Date: April 24, 2018

From: Charles K. Cothorn, P.E.

Subject: Springs at Waterview

This memorandum has been prepared to provide response and clarification to the GMS letter dated February 22, 2018. The comment is listed followed by the response. Please find attached 3 sets of the revised plans for the above referenced project for your review along with a copy of the plat. One of the sets and a copy of the plat has been provided to GMS, Inc. for their review.

PROJECT **SPRINGS AT WATERVIEW**
SHEET TITLE **WOLF MOON - P&P (1 OF 2)**
FROM **0+00** TO **3+00**
JOB NO. **0102.1** SHEET **7** OF **19**

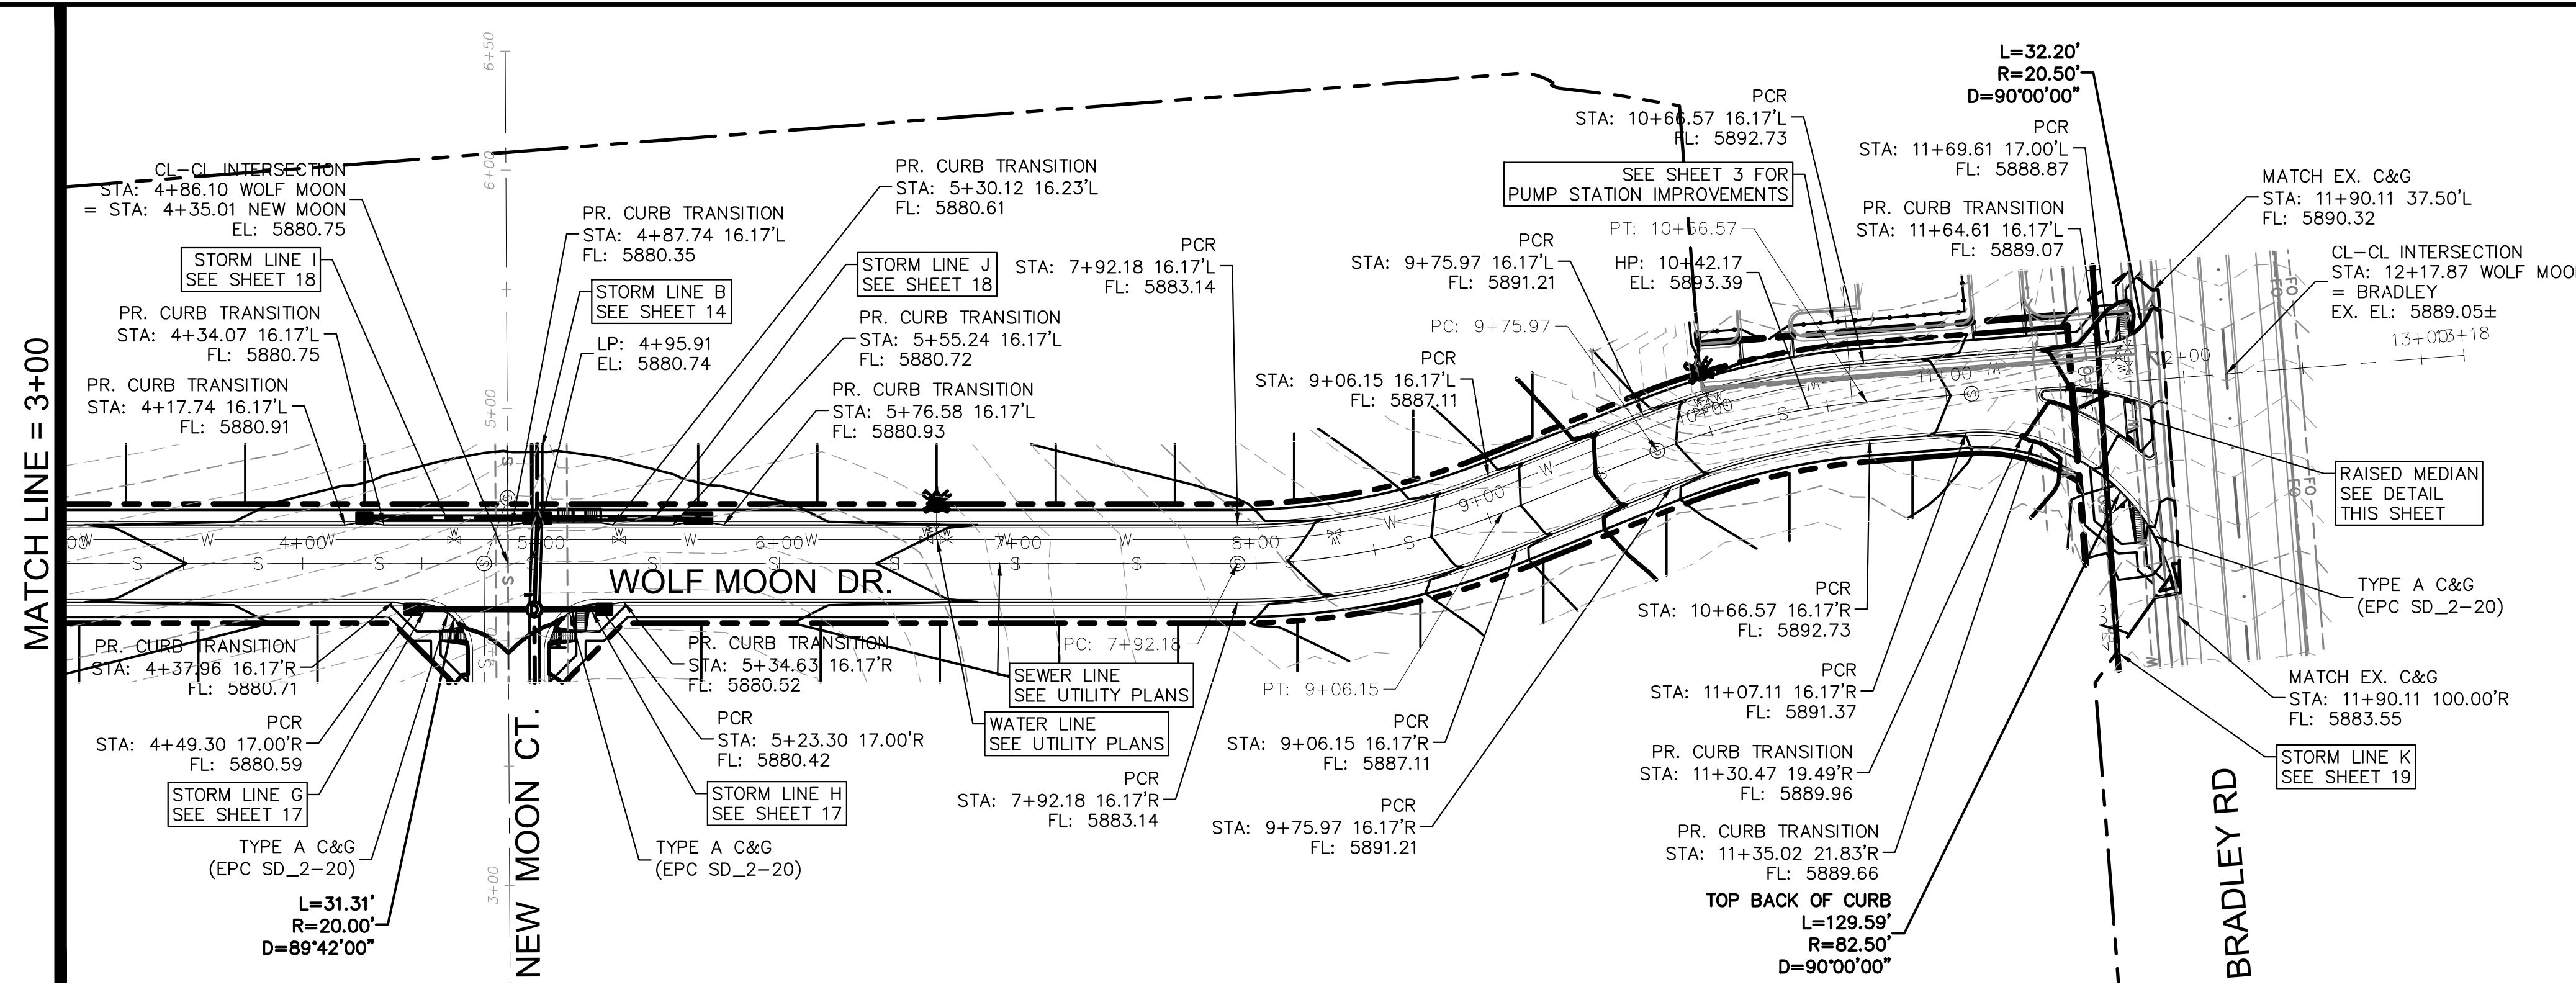
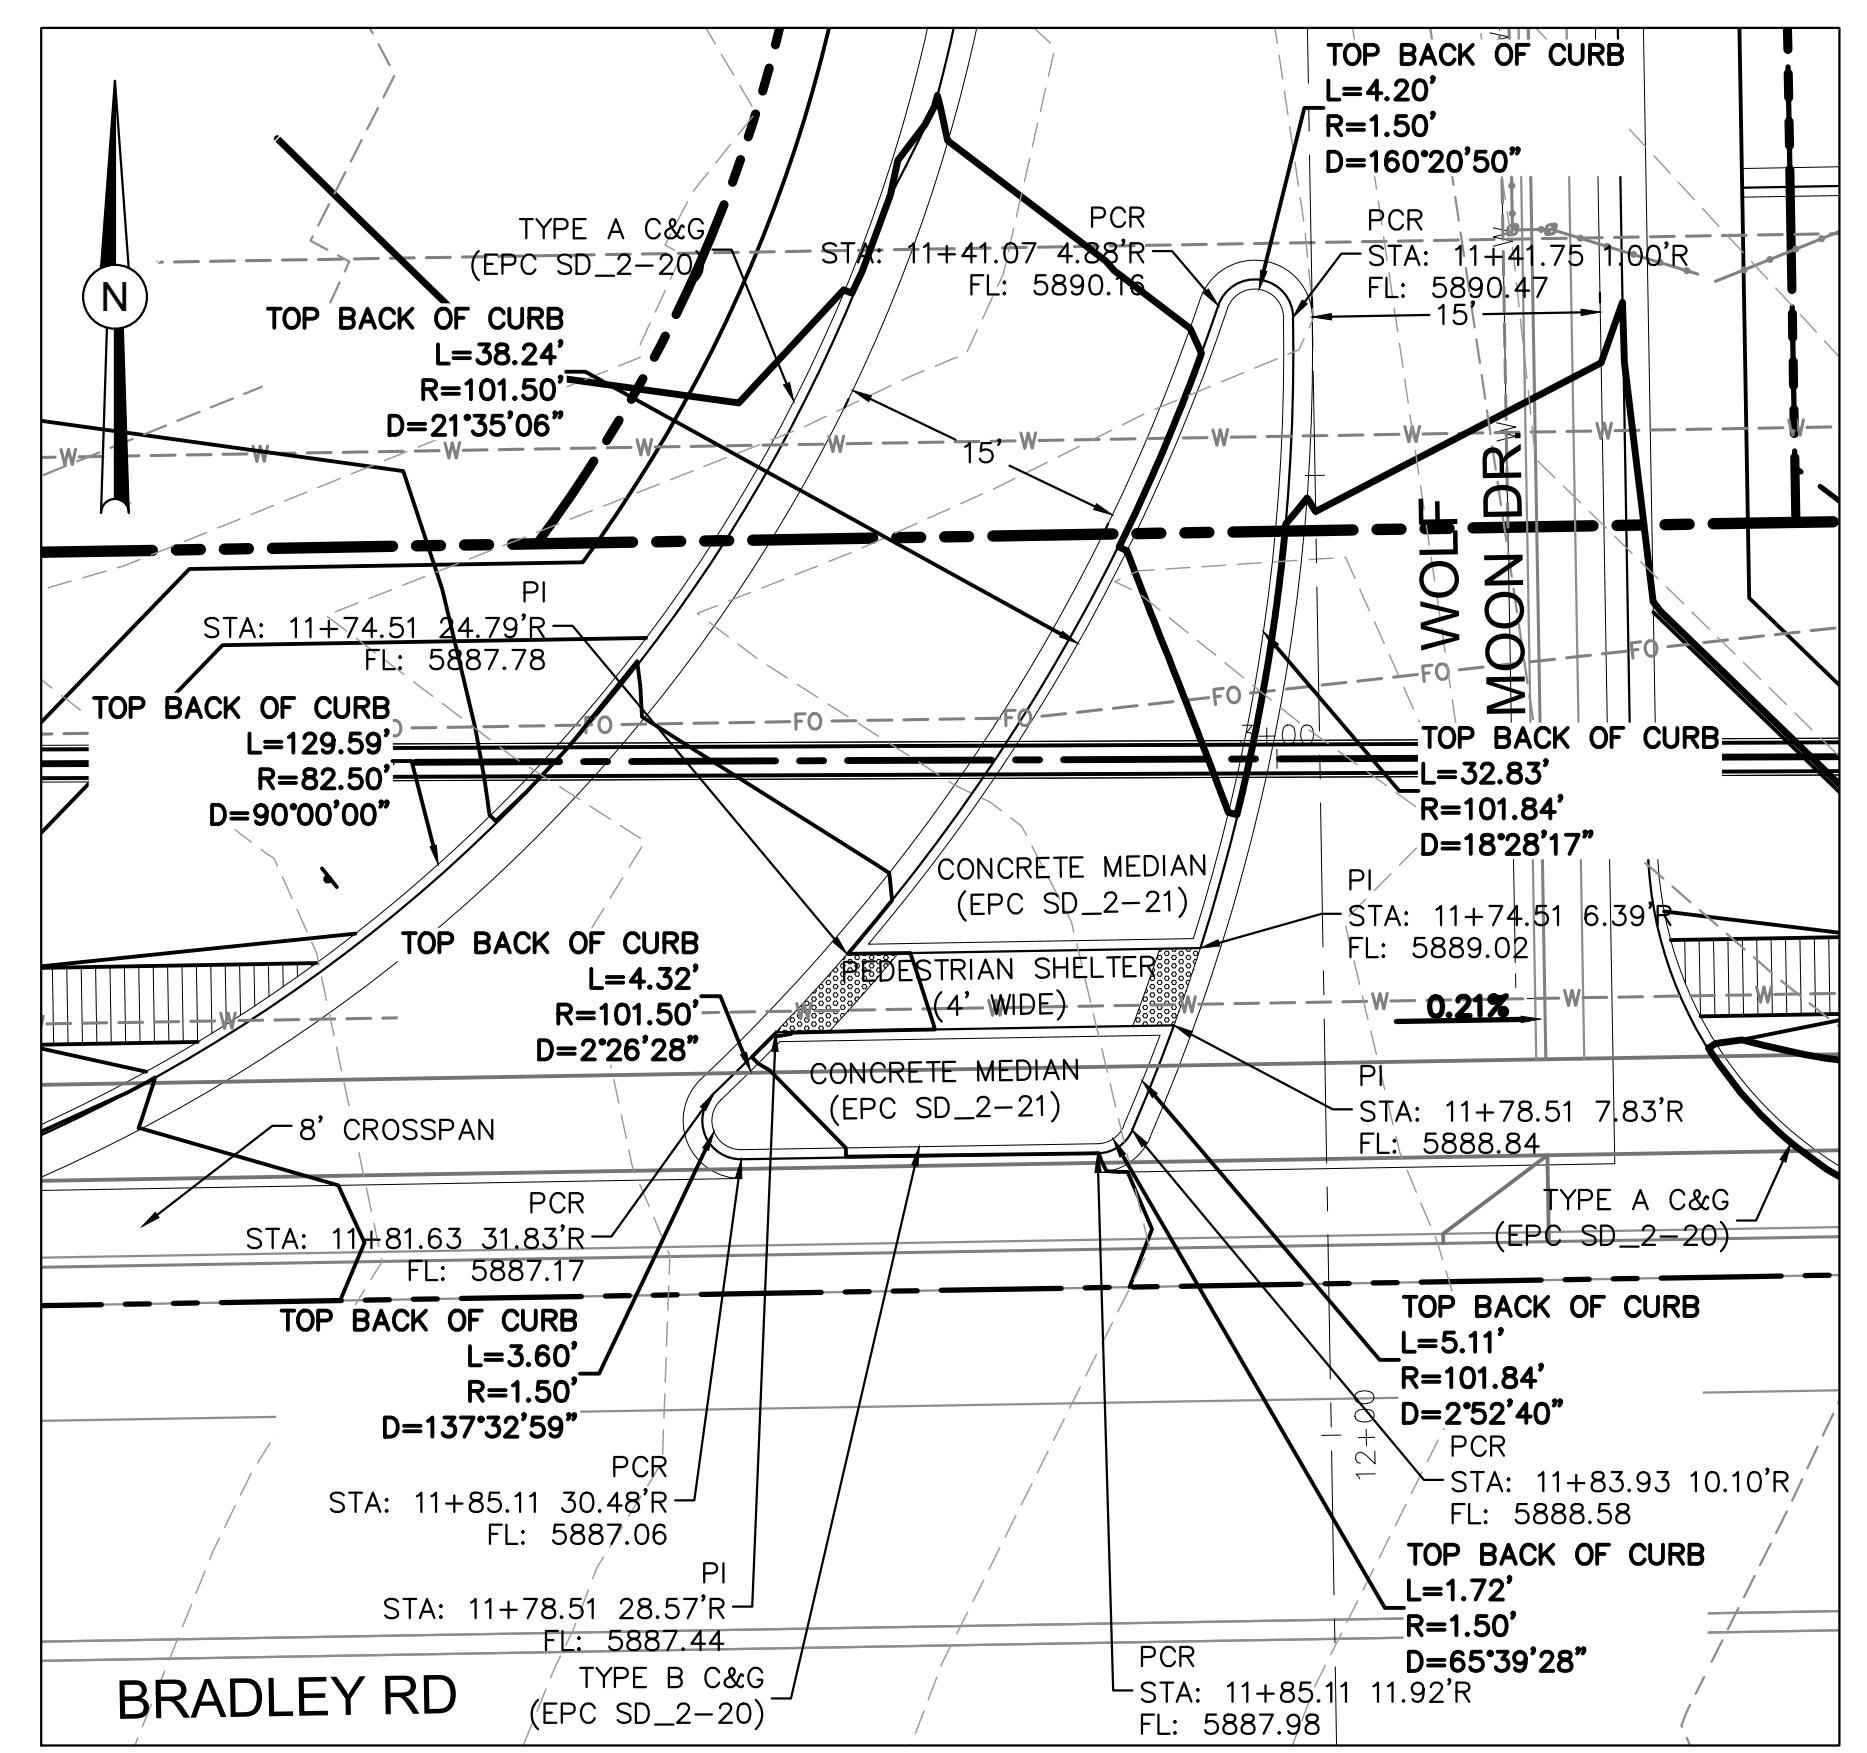
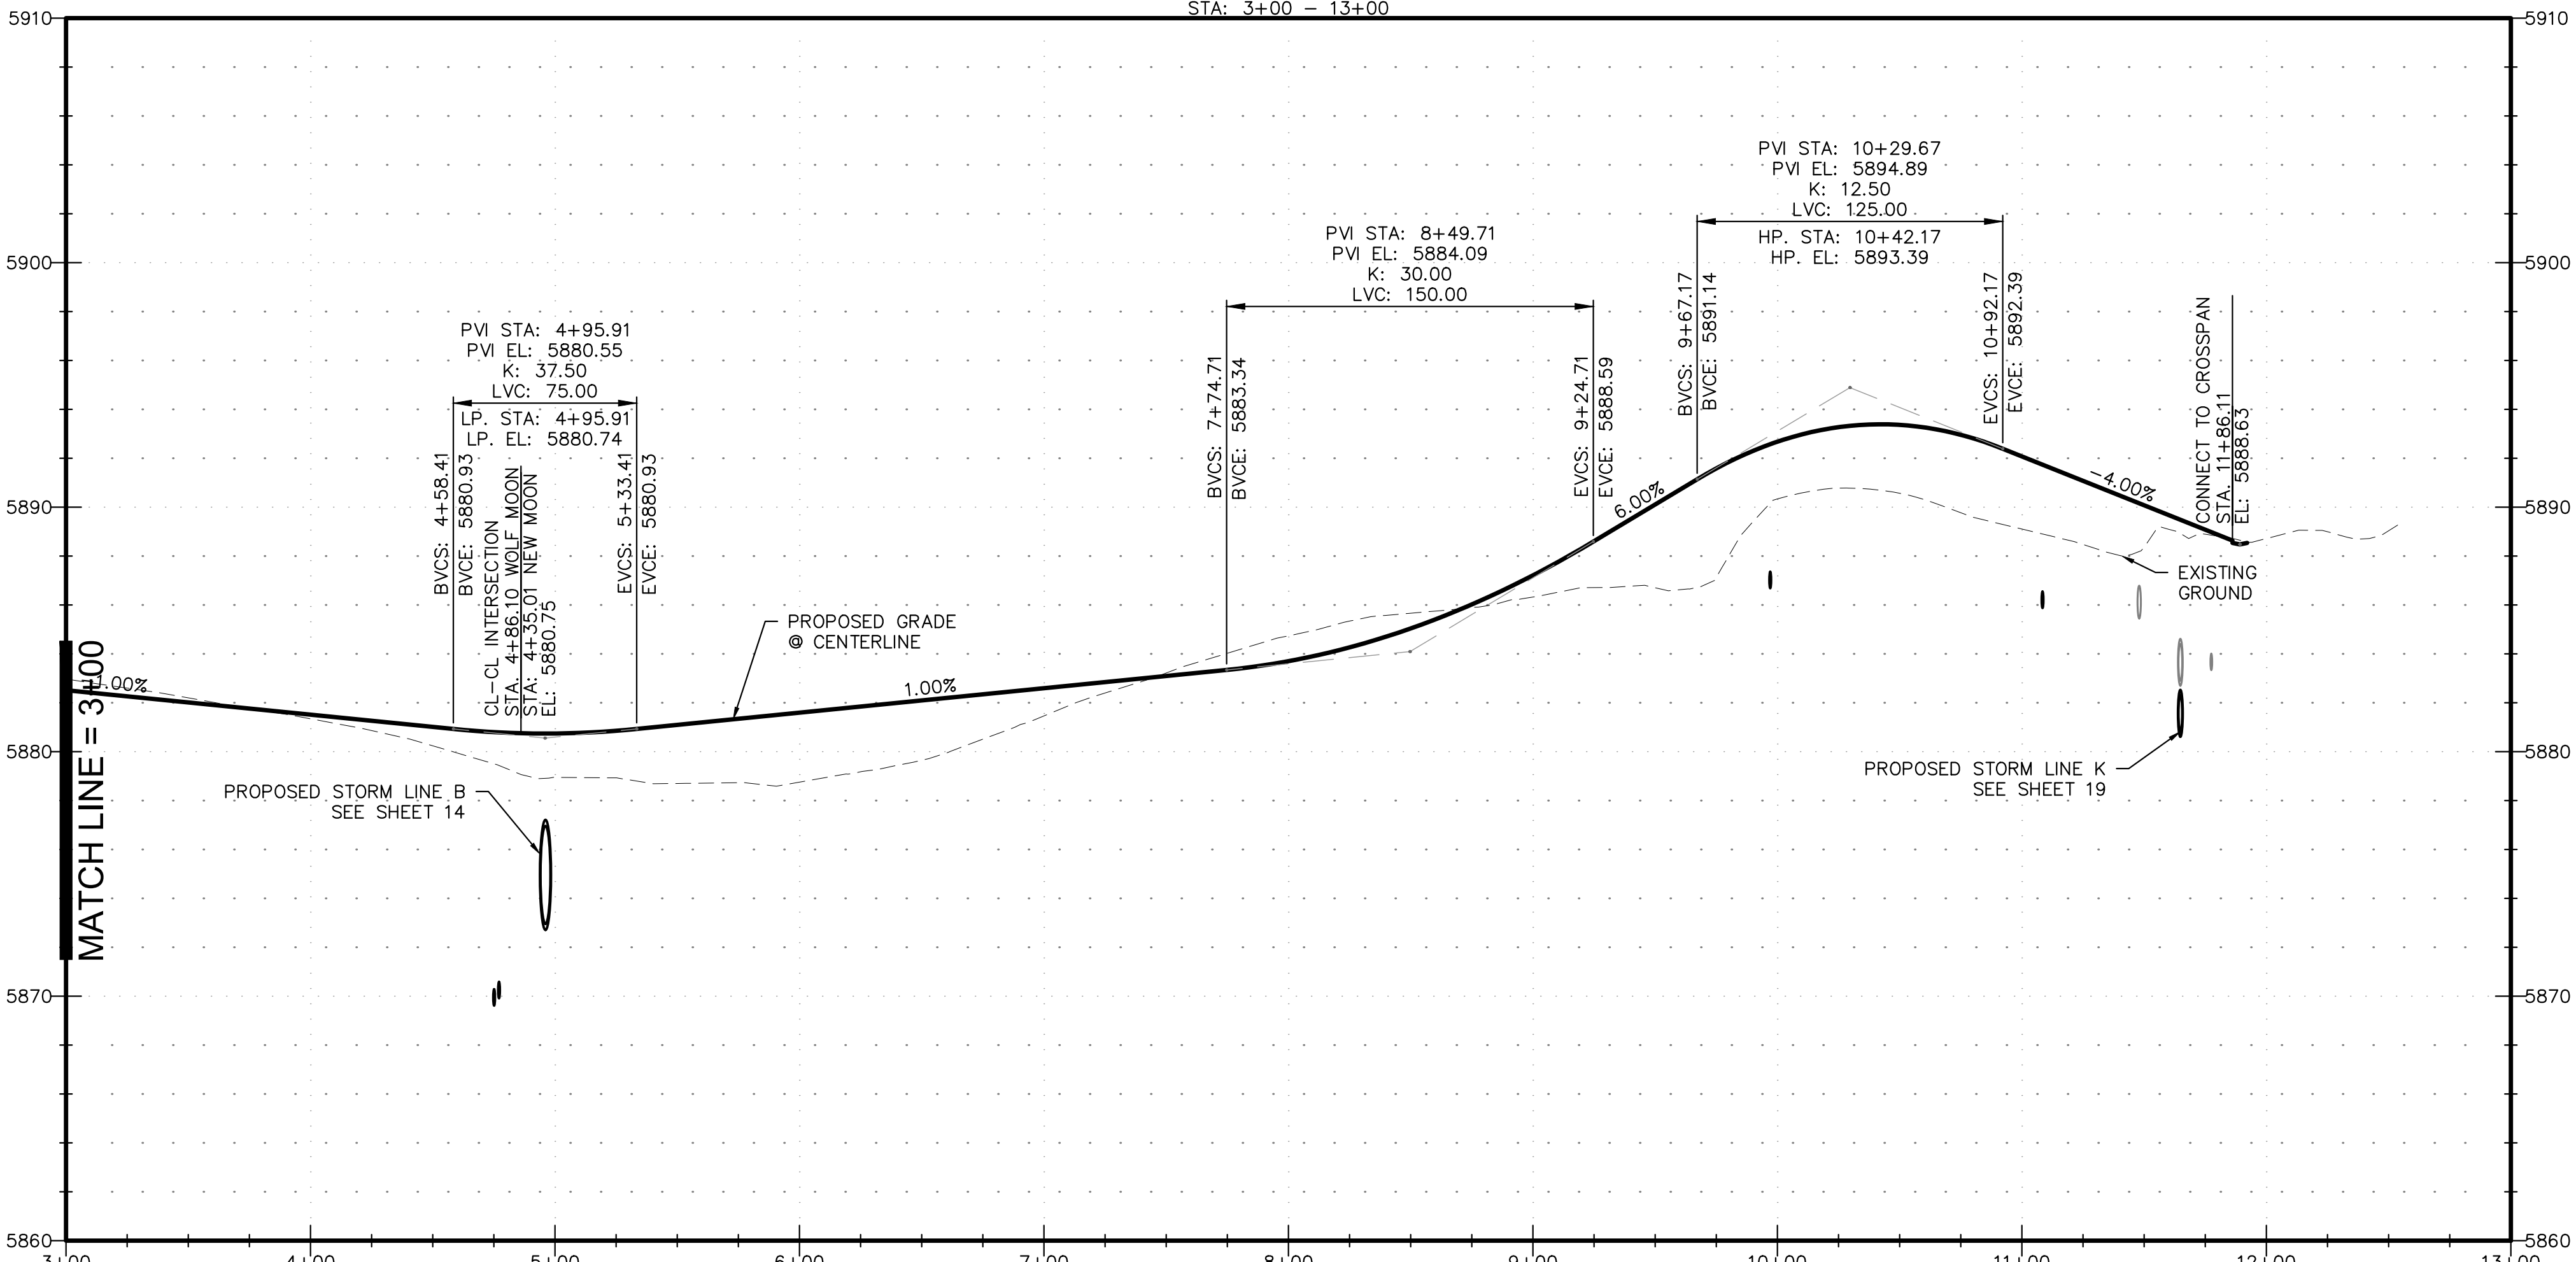
1. All proposed water mains shall be ductile iron instead of PVC. Please revise all water main material callouts accordingly.

2. In order to minimize access restrictions for fire suppression personnel, the fire hydrant shall be relocated from the end of the cul-de-sac to a location opposite the common front lot corner of Lots 13 and 14.

DSE Response: Water layout has been revised to be DIP throughout the project.

DSE Response: Hydrant locations have been revised per criteria discussed in meeting with Roger Sams held 3/22.
